October 17, 2024

**RE: *McDonald's – Village at Lorson Ranch Filing No. 1 Lot 2***

## **COMMENT RESPONSE LETTER**

TITLE	DATE	BY	DESCRIPTION
SITE DEVELOPMENT PLAN	7/30/2024	JJM	COVER
COVER	7/30/2024	JJM	
SITE ID	51028		
SITE ADDRESS	6646 MARKSHEFFEL ROAD, COLORADO SPRINGS, CO		
EL PASO COUNTY	NO. EA2467

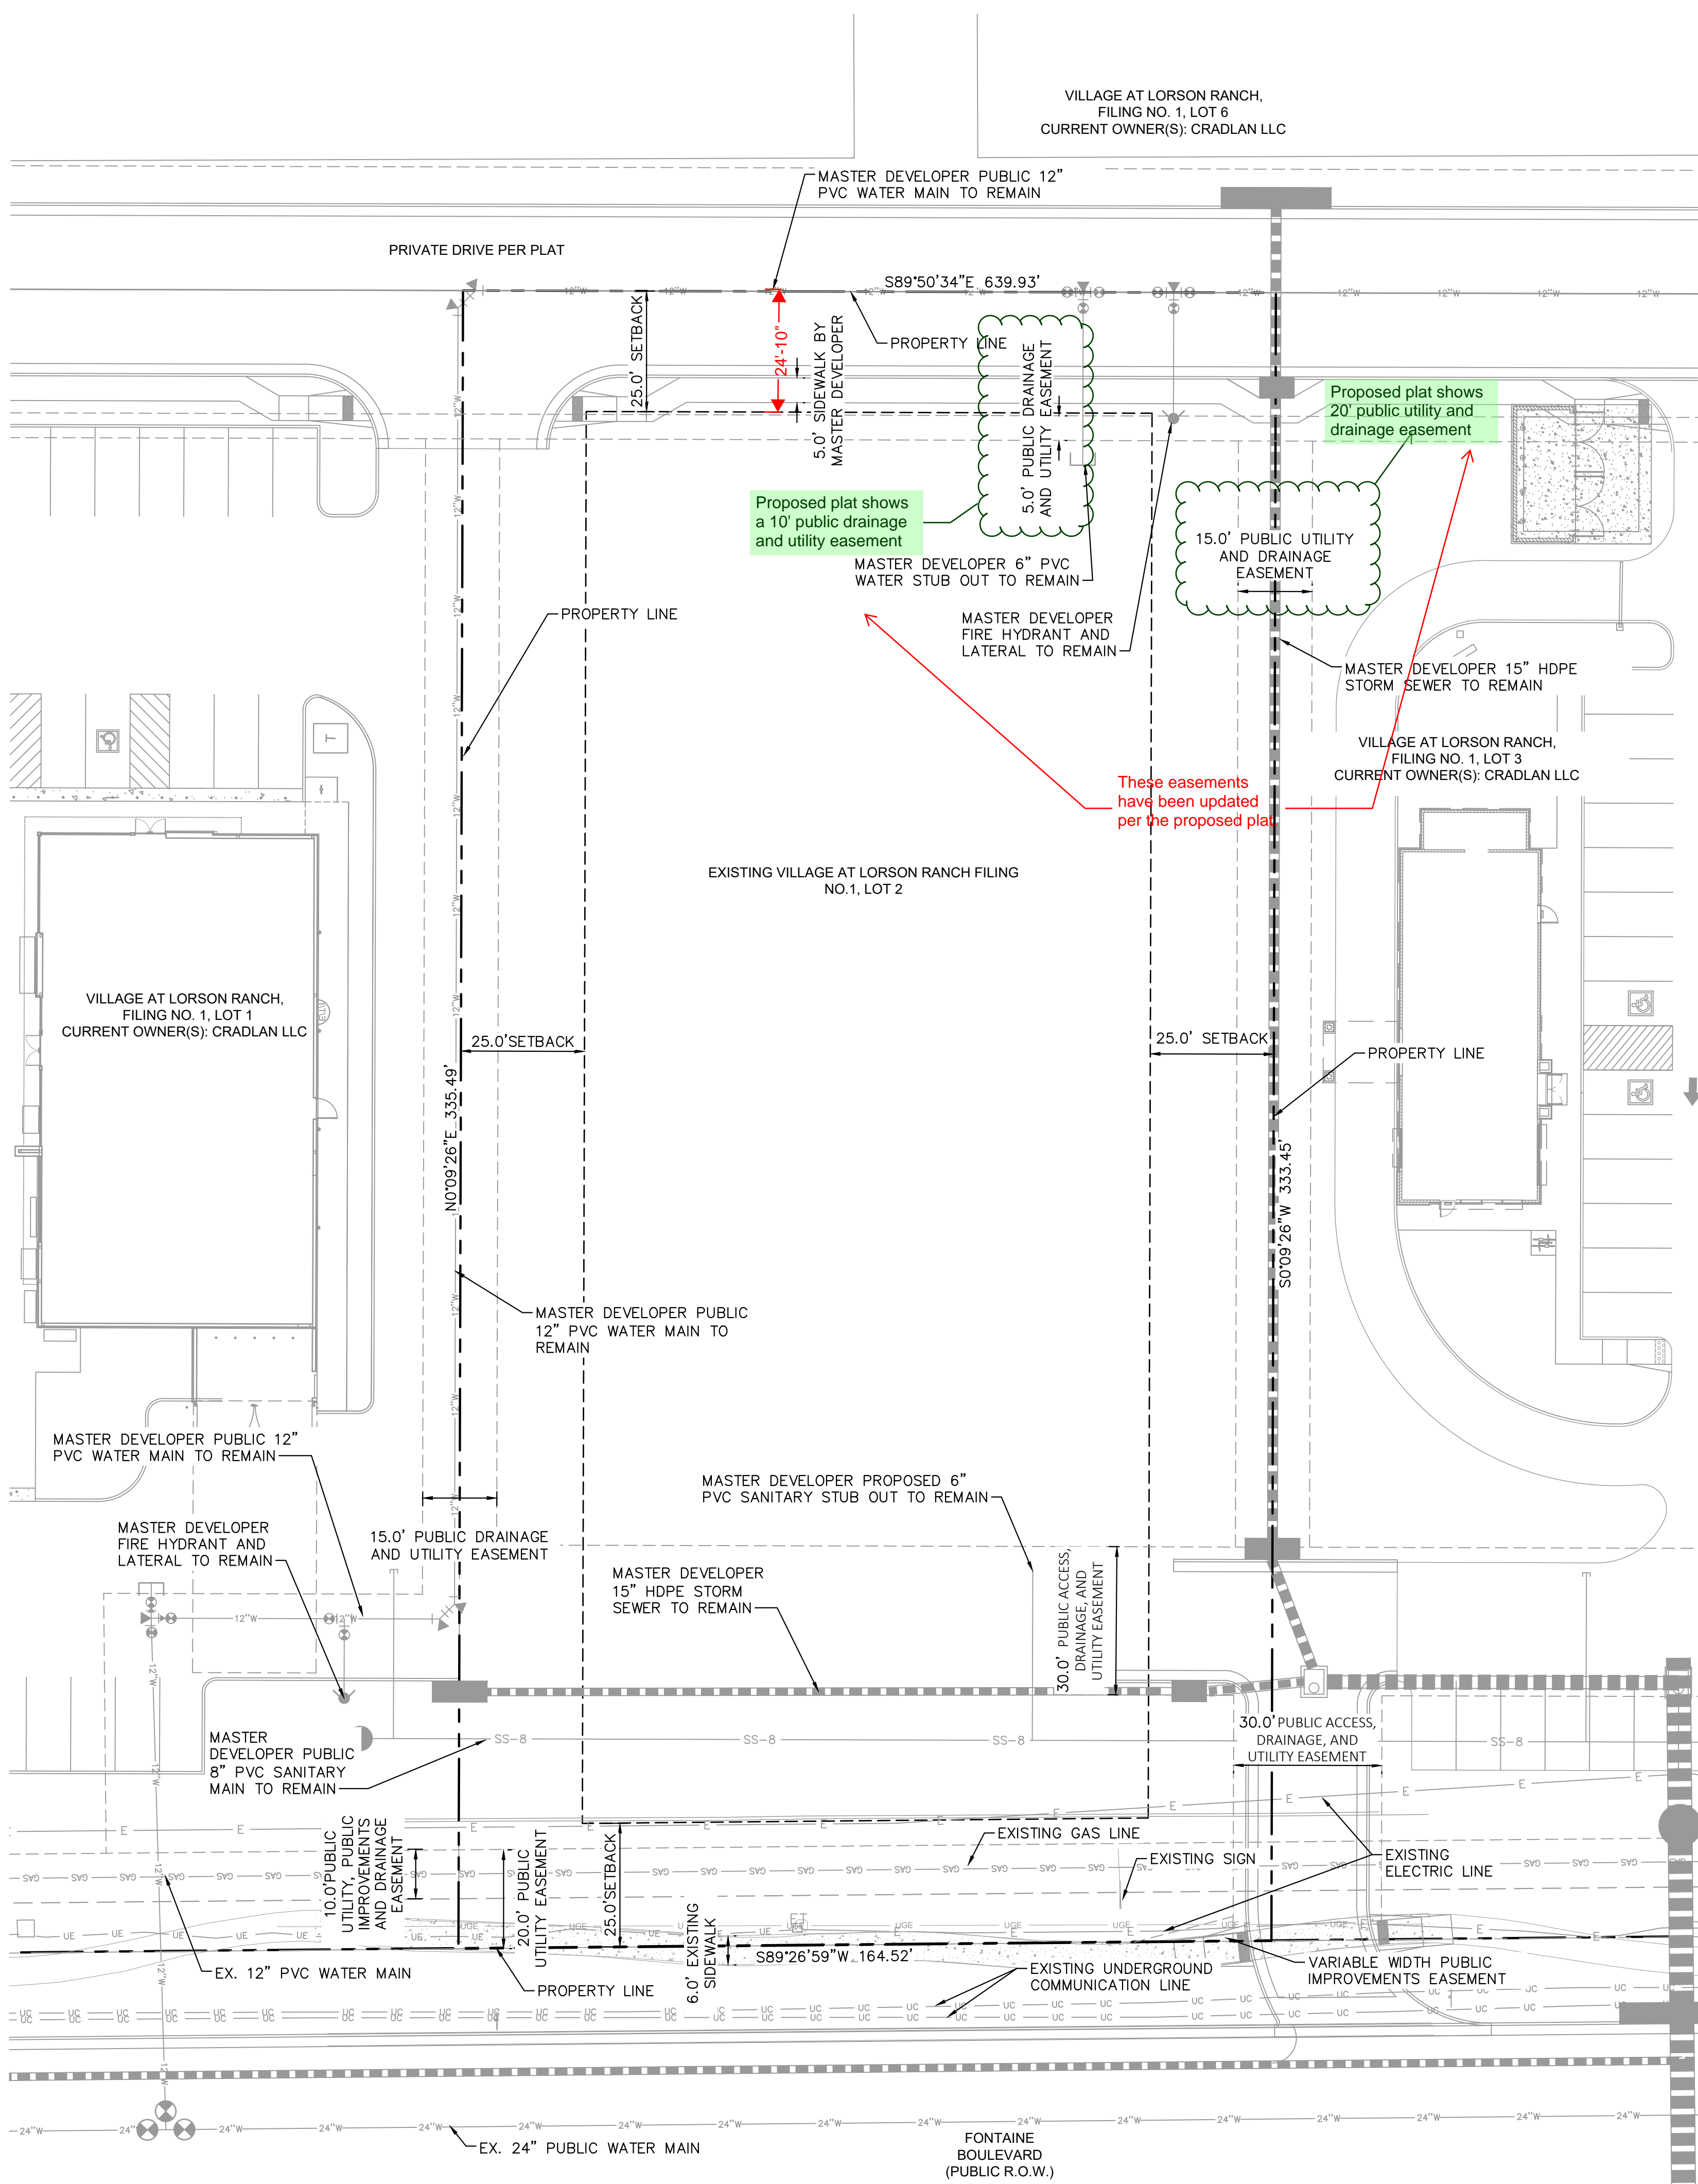
14. In the title block of the first page of the developments plan the title block & below legal description of the parcel should read; The northeast quarter of the NORTHEAST quarter, not northwest.

- **Response:** *The address previously provided on the coversheet was incorrect. Please reference the parcel number instead to get info from County Assessor. Based on the Plat draft from the Master Developer/ALTA survey, the legal description will be “the S ½ of the SE ¼ of Section 15...”.*

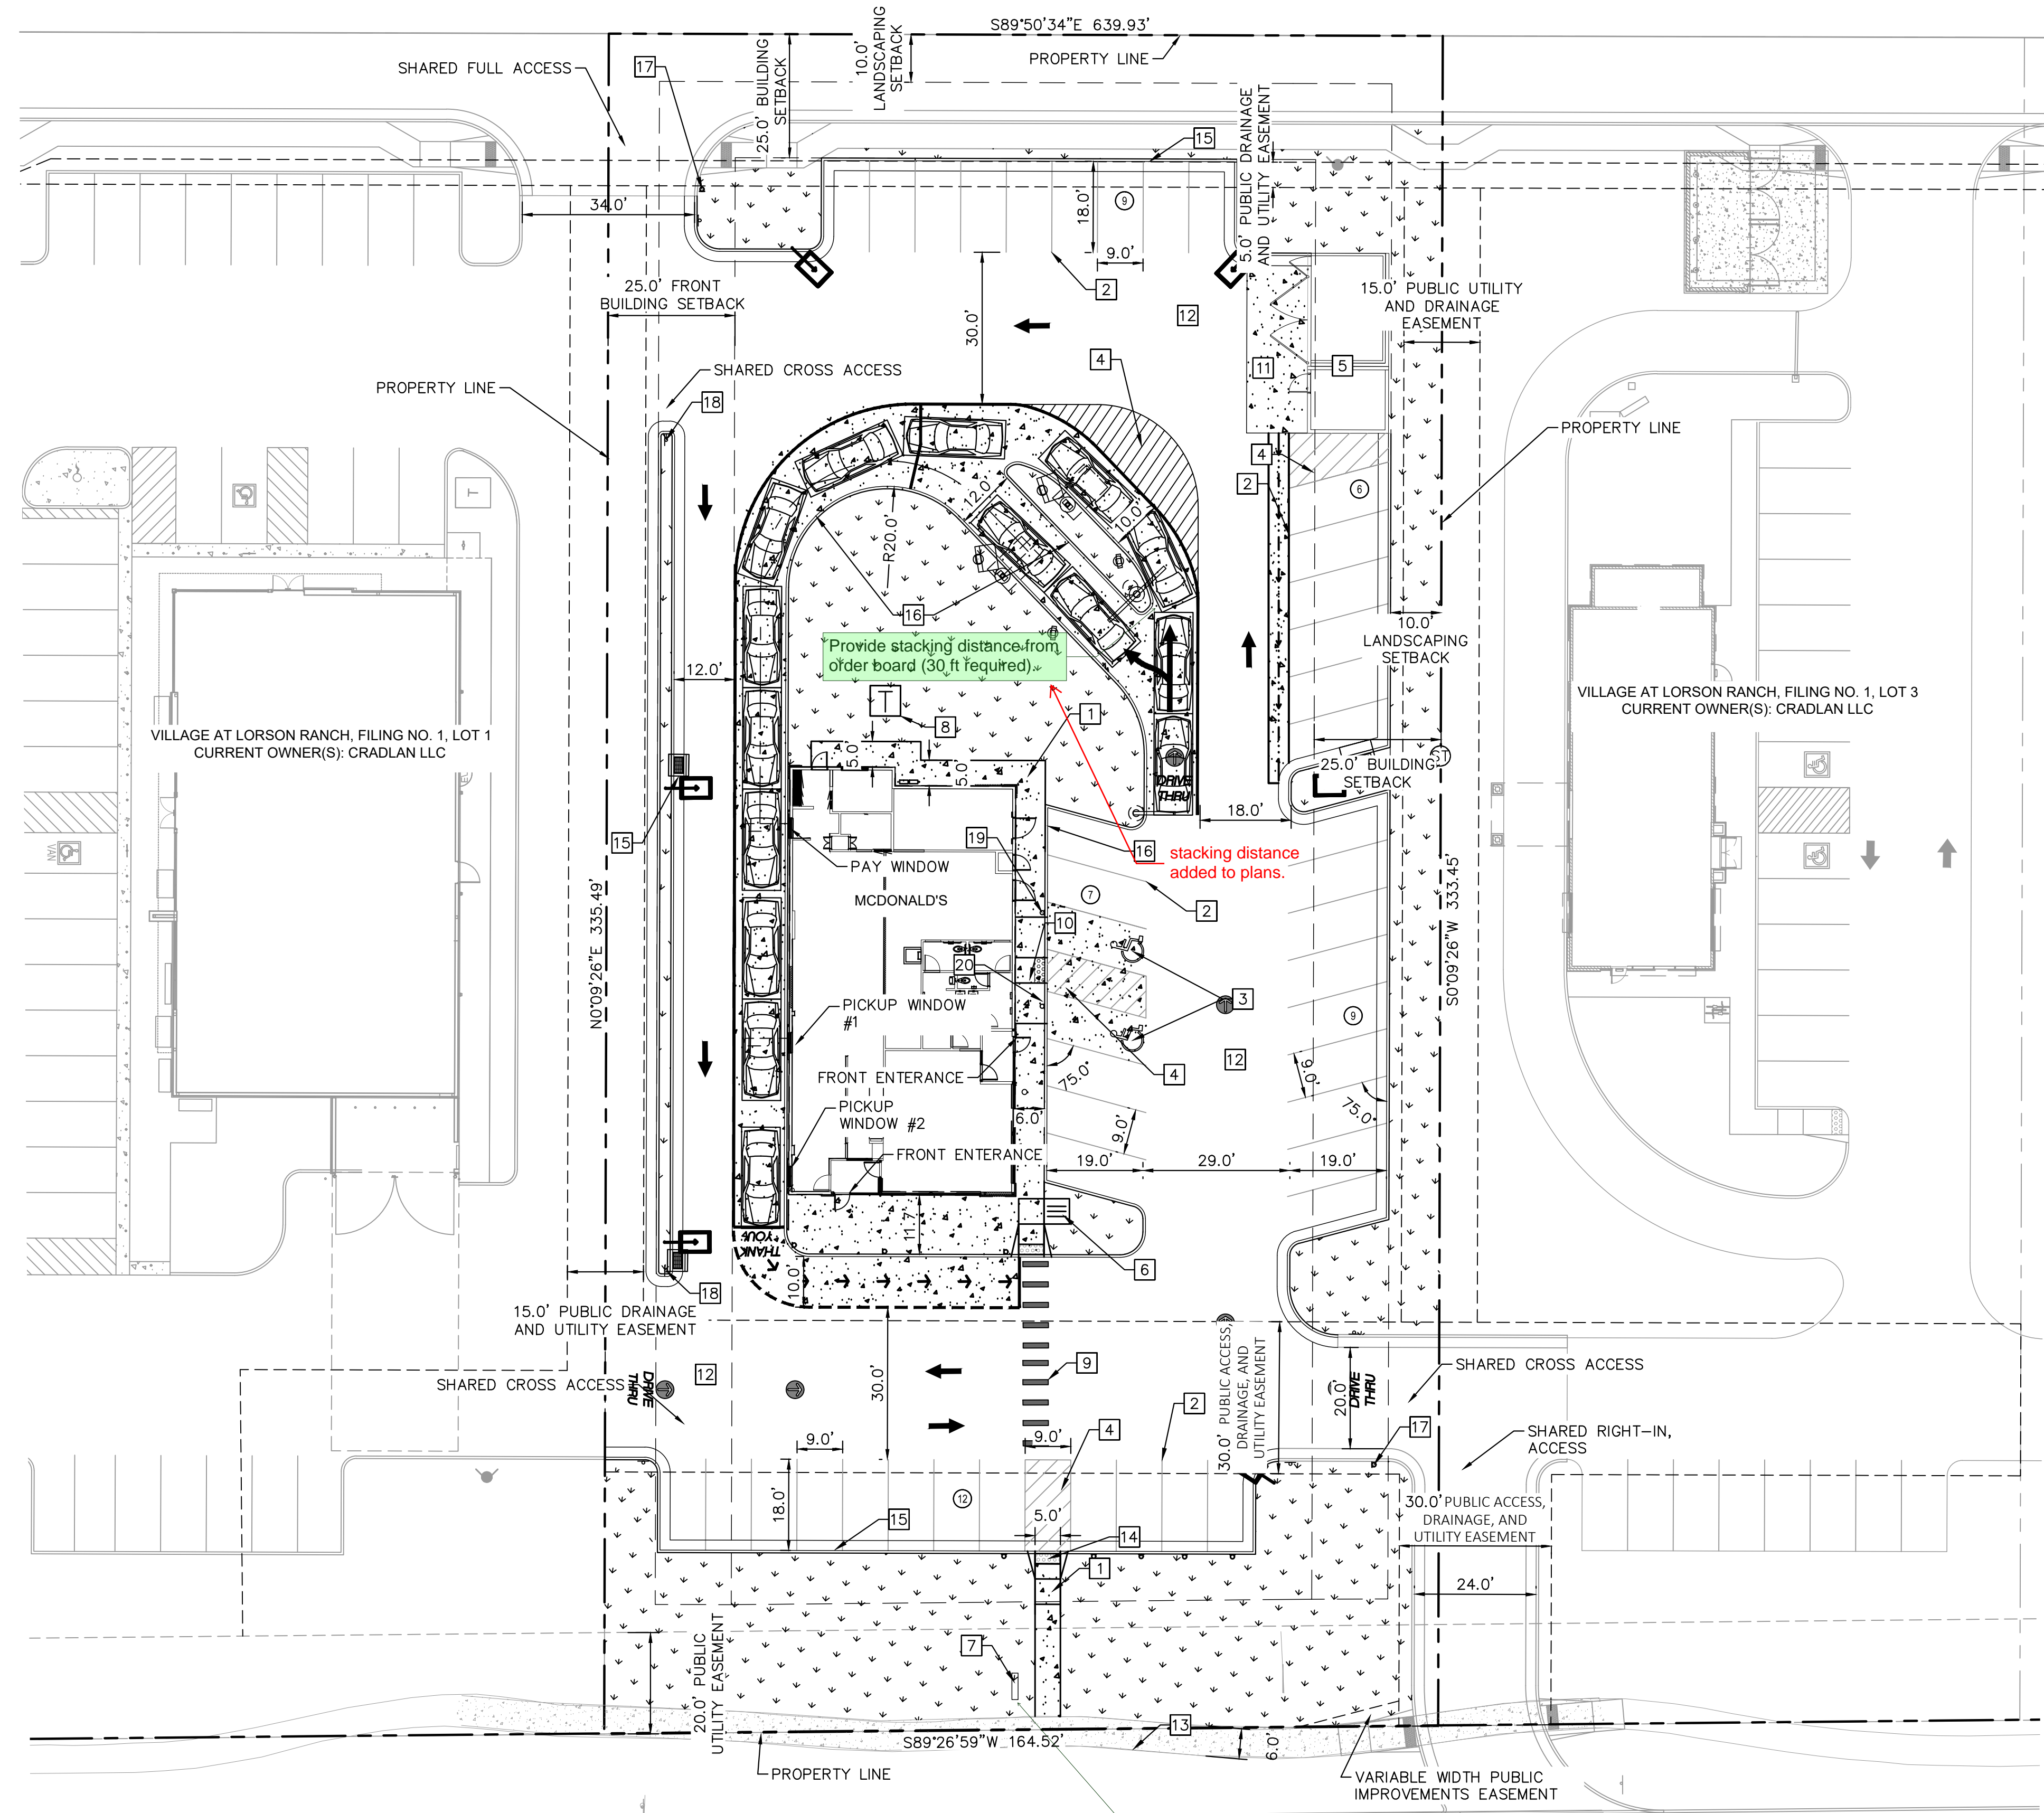
16. How tall is the 2 proposed gates and fencing? If the fencing and gates exceeds 7, a separate address will need to be assigned along with a separate permit. Please clarify.

- **Response:** *The trash enclosure, which includes gates/screen walls, is to be max 6-ft tall. The storage facility attached to the trash enclosure is to be 9’-6” tall. The address for the storage facility has been coordinated with PPRBD Enumerations via the permit team (Rogue Entitlements) and was assigned 9670 Fontaine Blvd.*

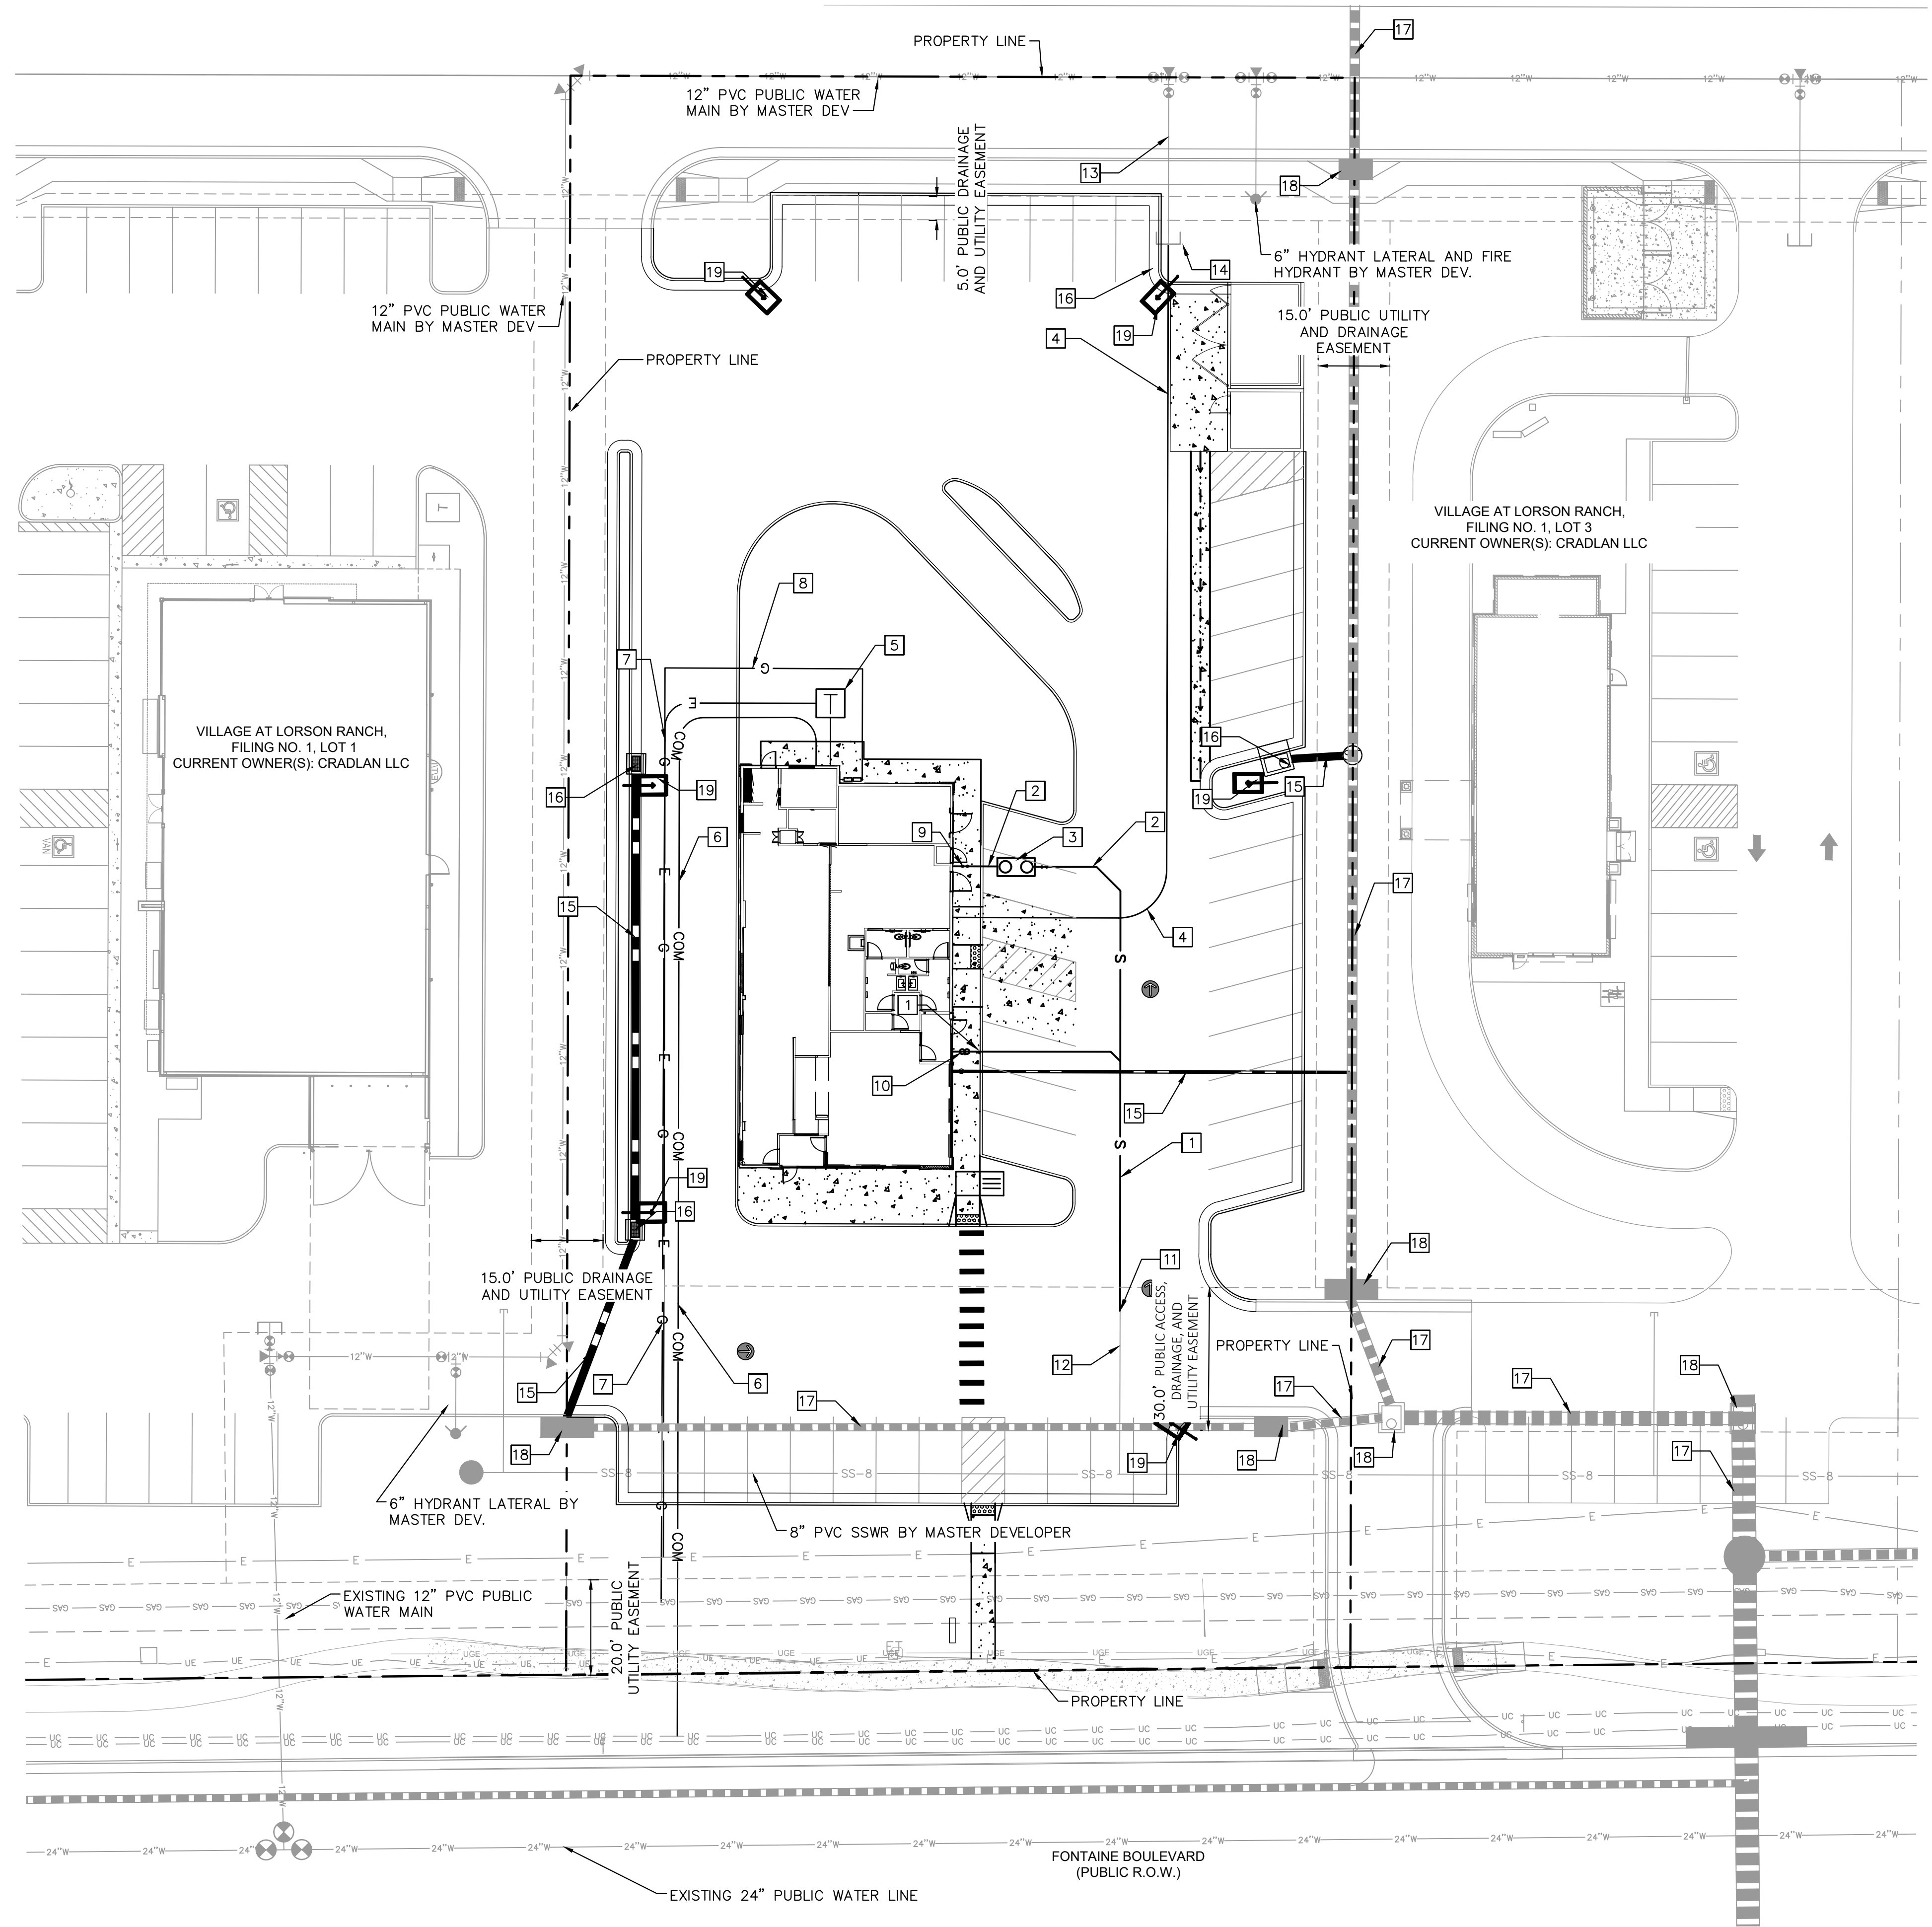
18. Callout Backflow Preventer.

- **Response:** *Backflow preventer has been called out as requested.*
